Date: 28 January 2021

### **Application by London Resort Company Holdings for an Order Granting Development Consent for the London Resort**

#### **Advice following issue of decision to accept the application for examination**

Scale: **1 : 2500 @ A1** Sheet: **2 of 9** Revision: **0**

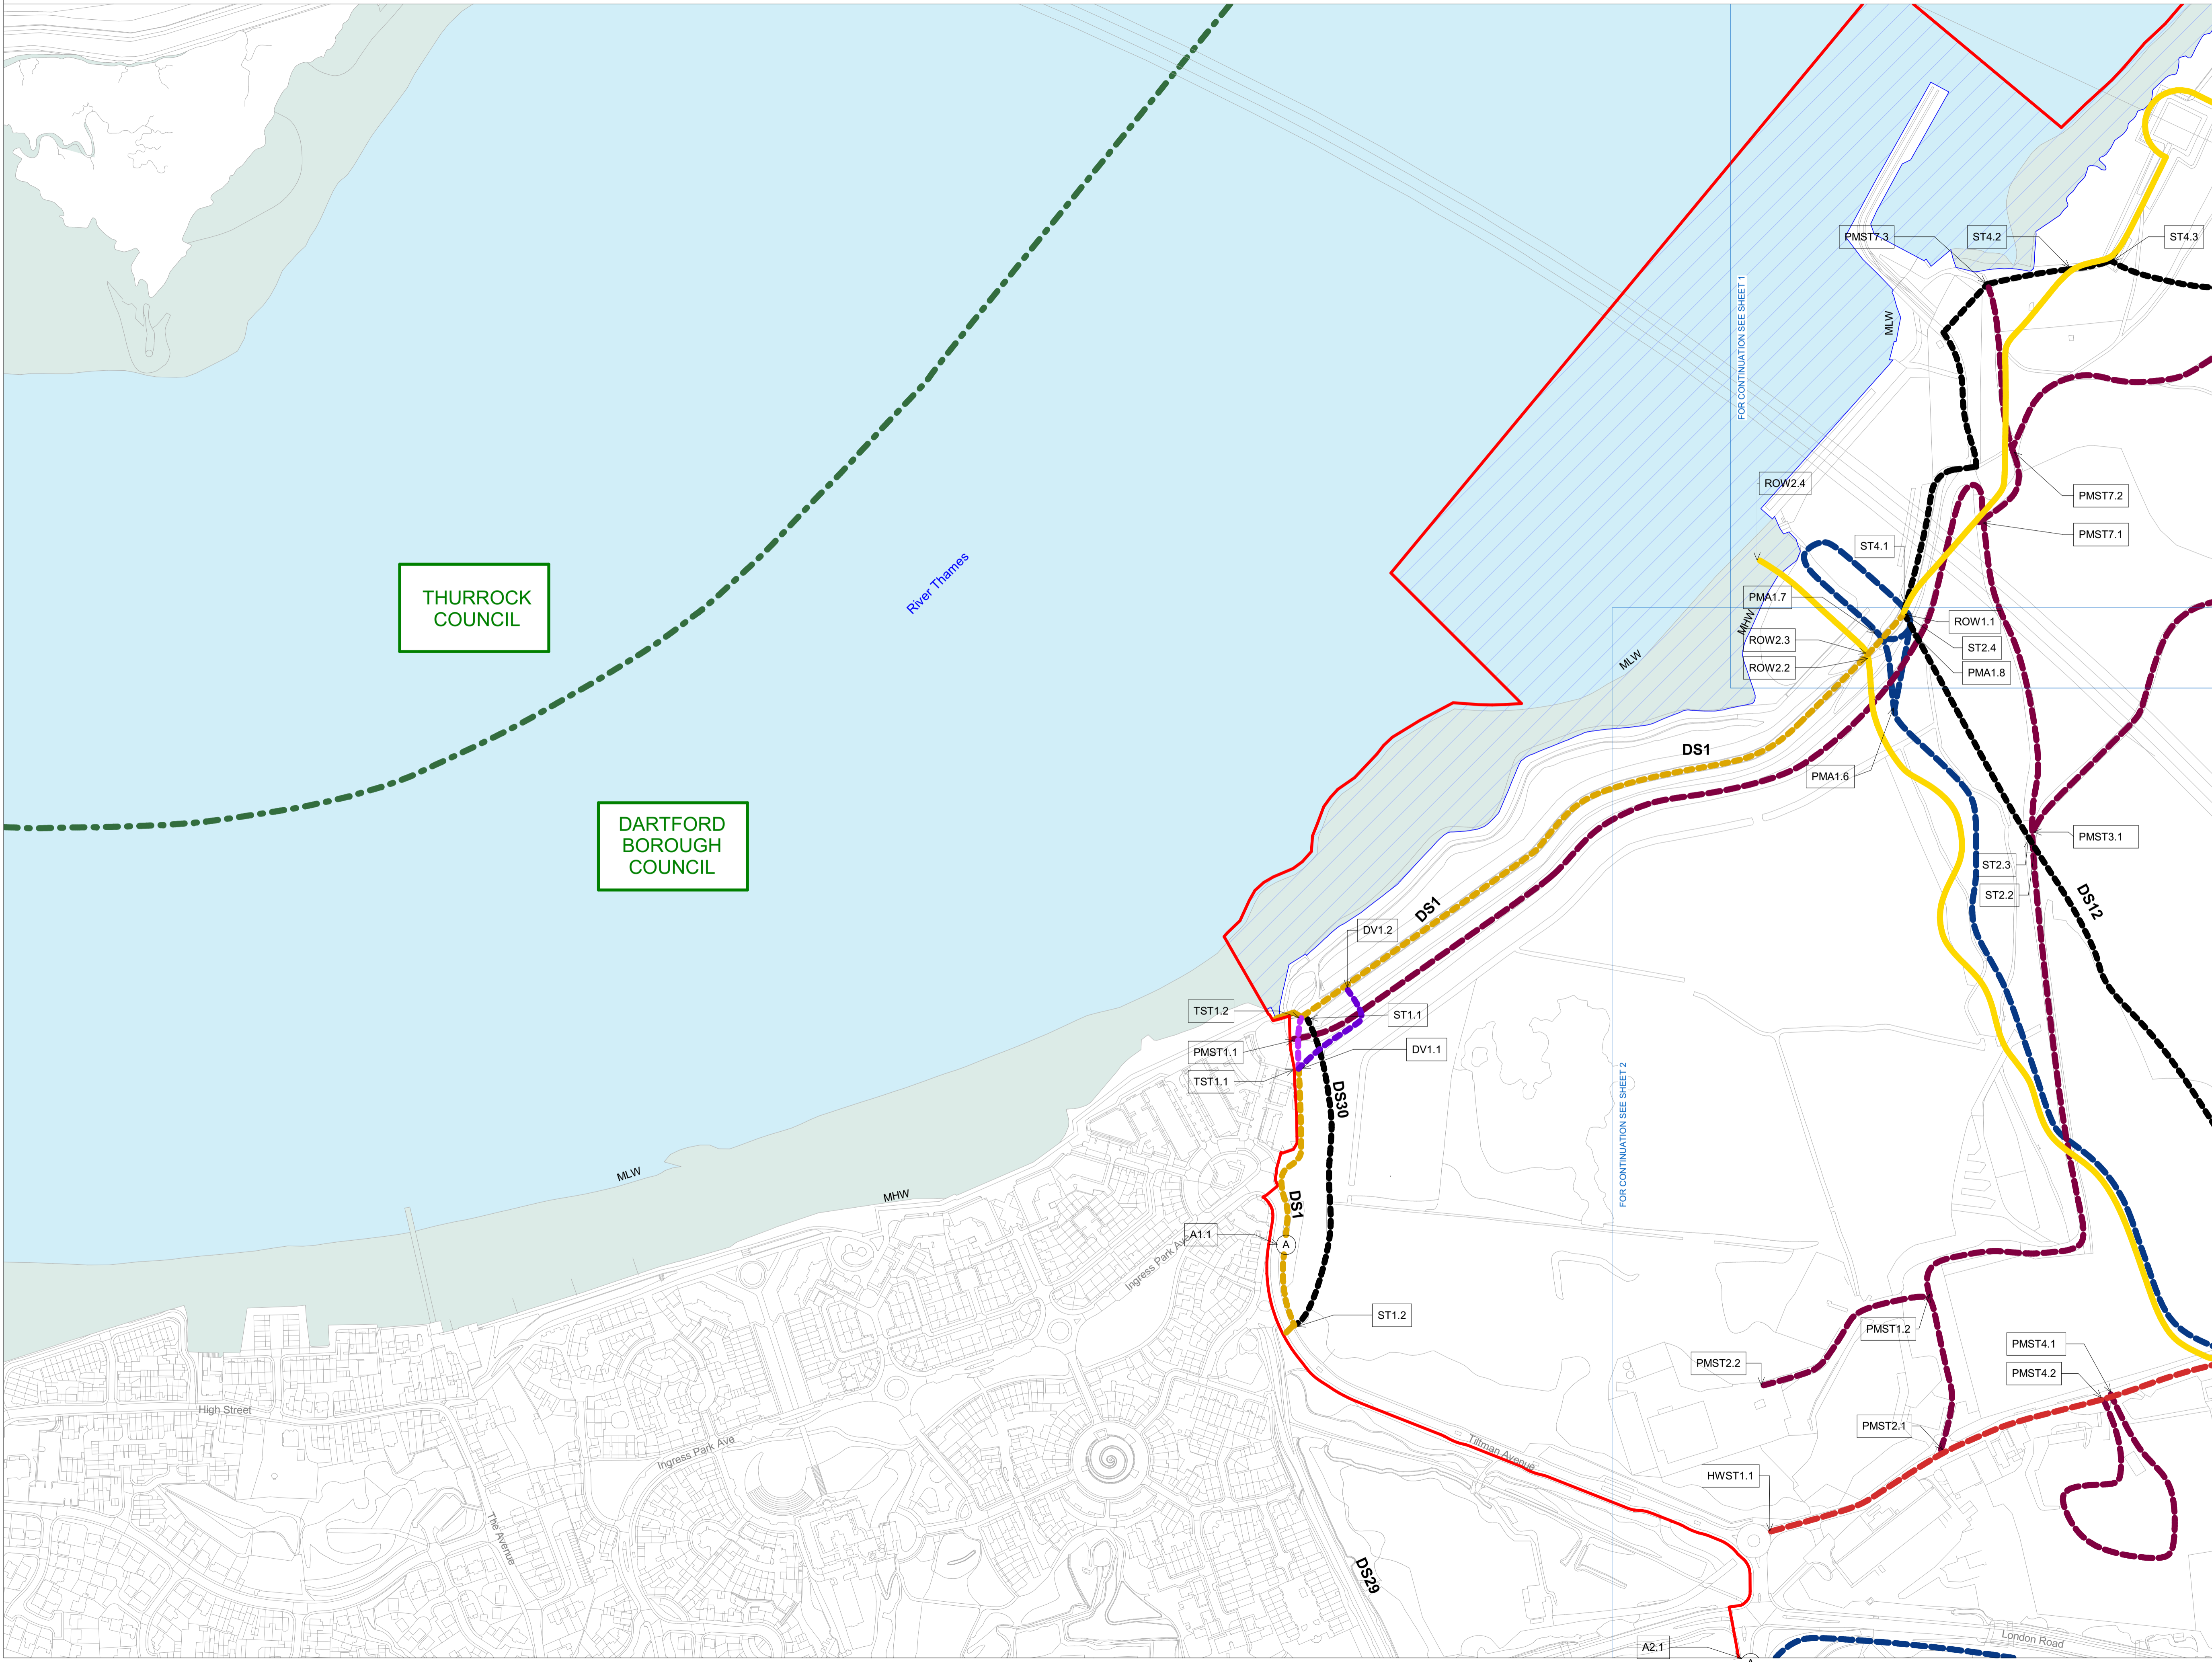
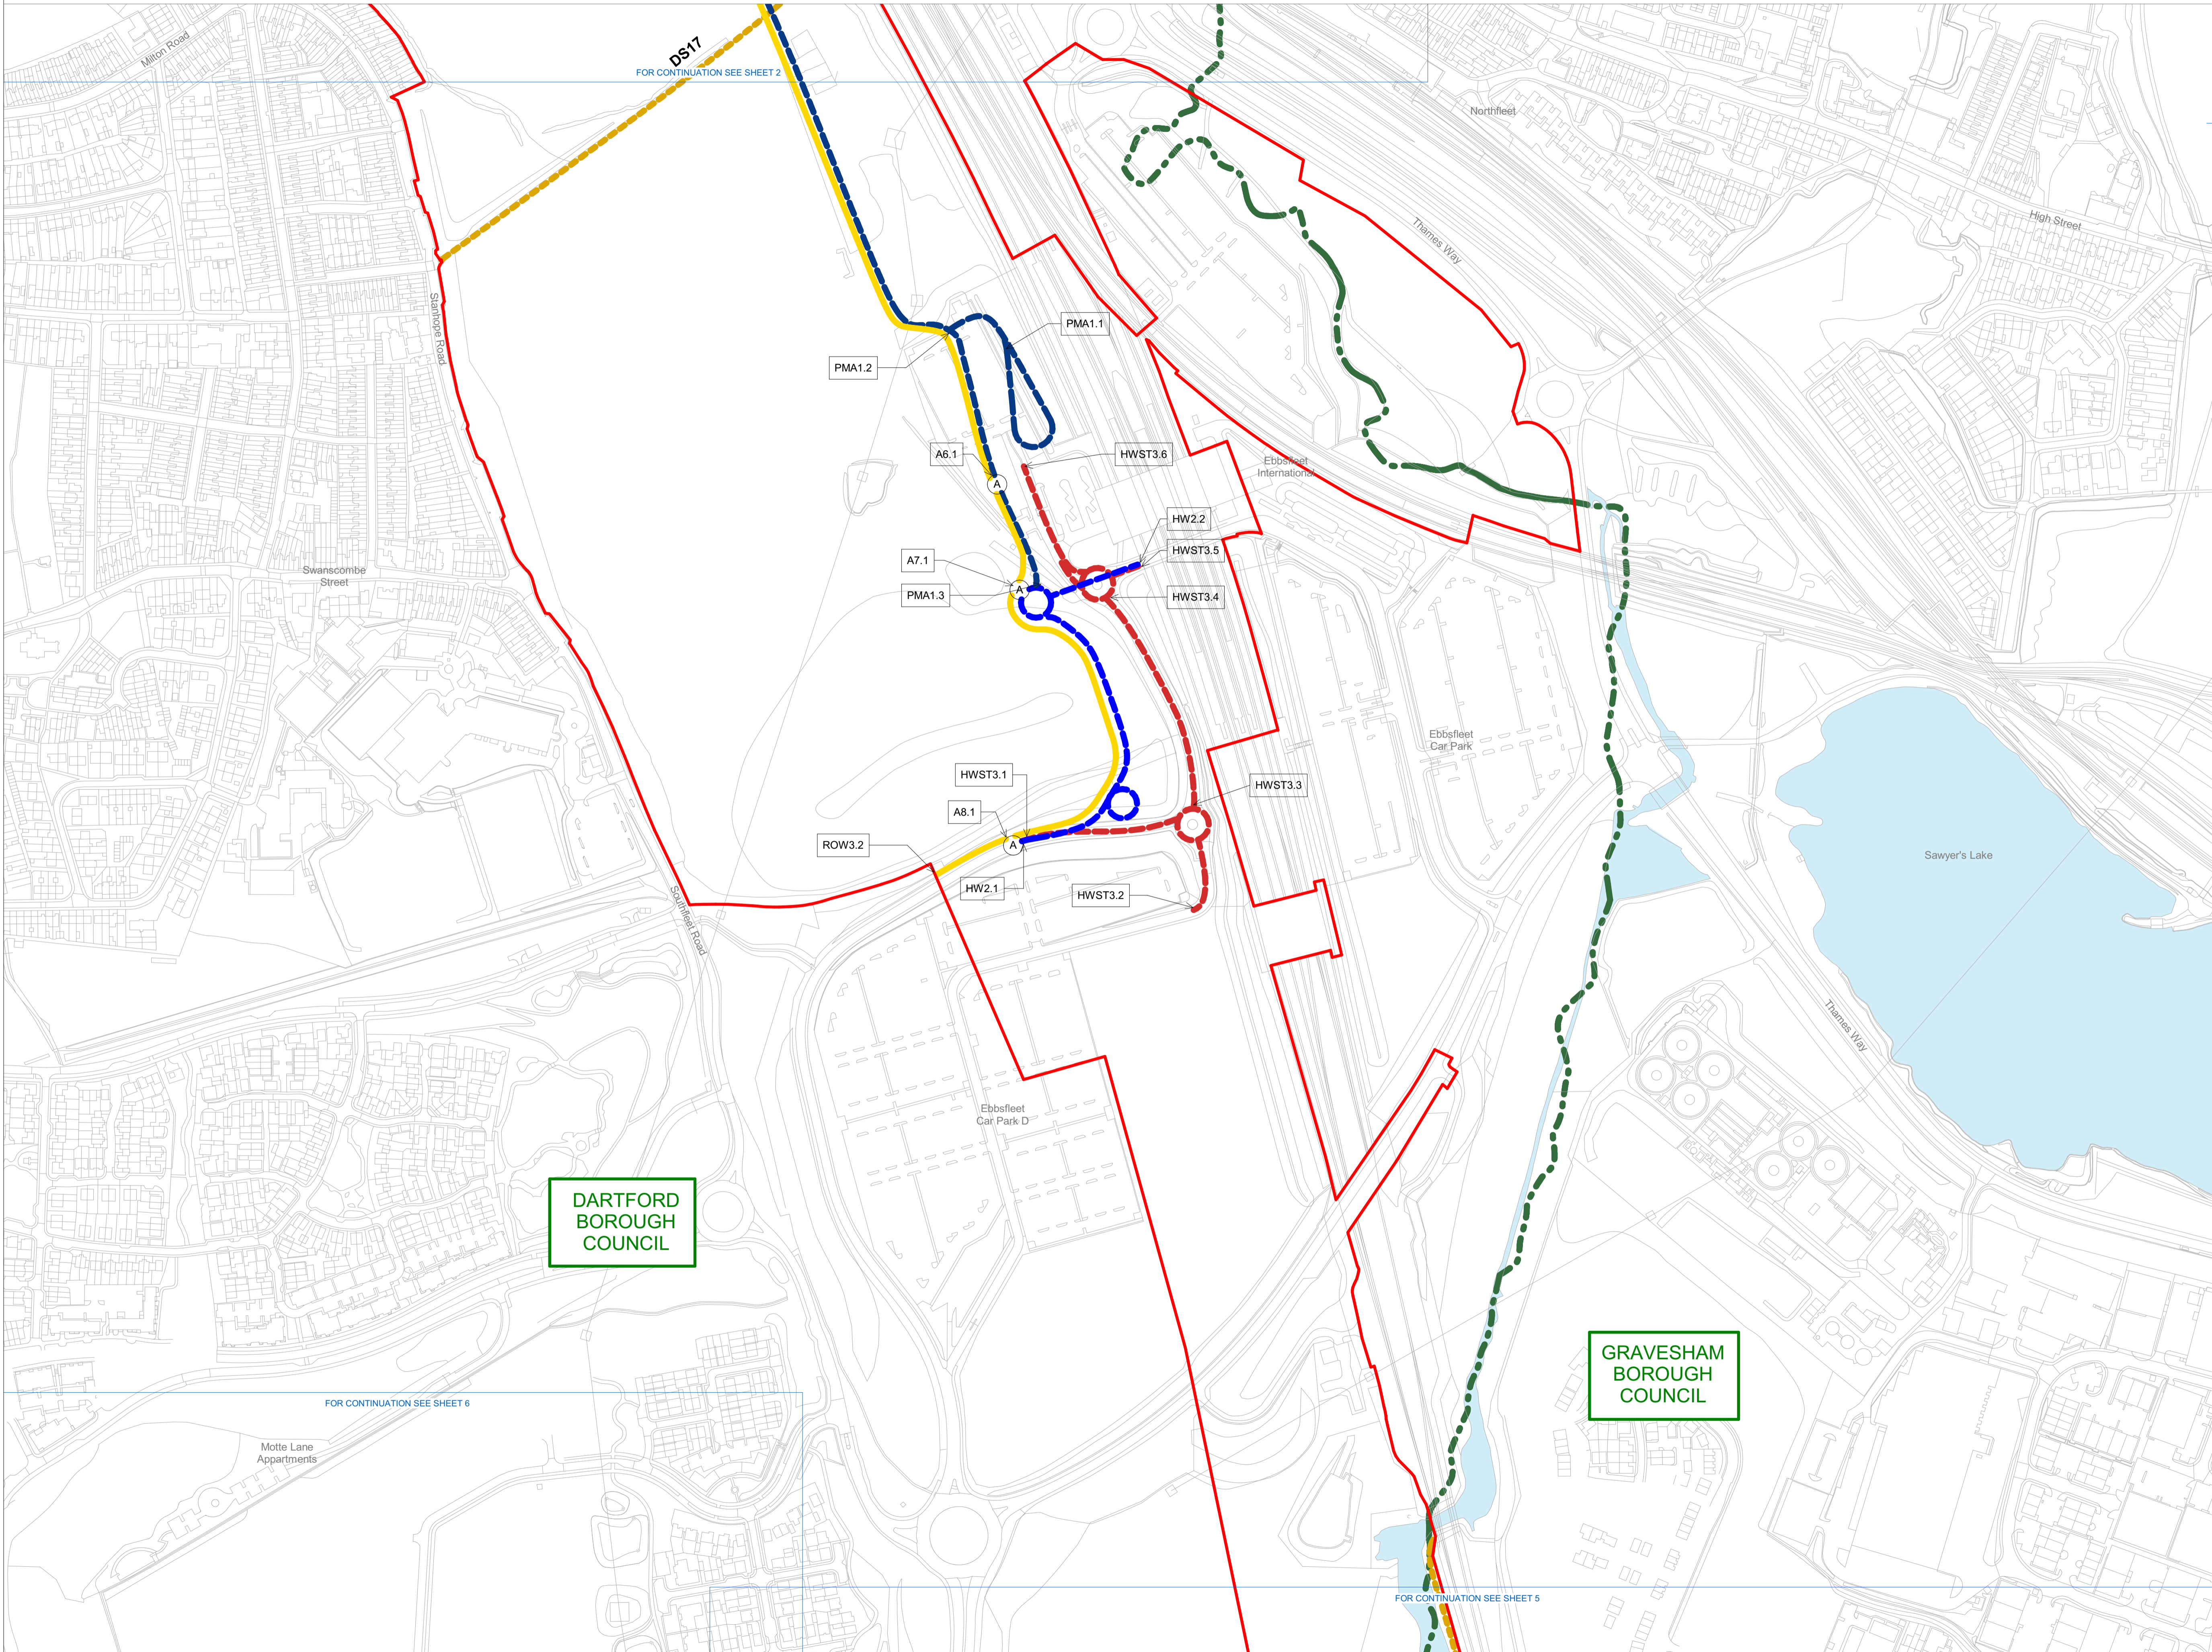
The Applicant is requested to provide updated plans which address the issues raised in Box 30 of the checklist
